Your Ref: OWPC26289
Our Ref: LU/84/20/PL 17-03-2020
Please ask for:
Mrs A Gardner

Change of use from newsagent (A1 Shops) to hot food take away (A5 Hot Food Take Away), external alterations to rear elevation & installation of roof mounted extract flue & fresh air intake pipe.

2 Wick Parade Wick Street Littlehampton

PROPOSED REAR
ELEVATION

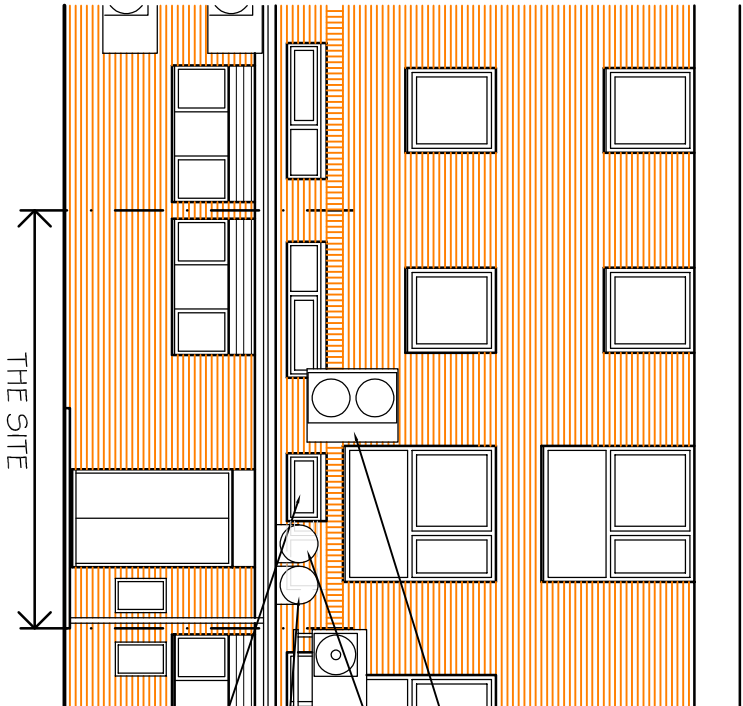
(1) much more detail is required on detail about noise and smell given the proximity of the residential units upstairs.
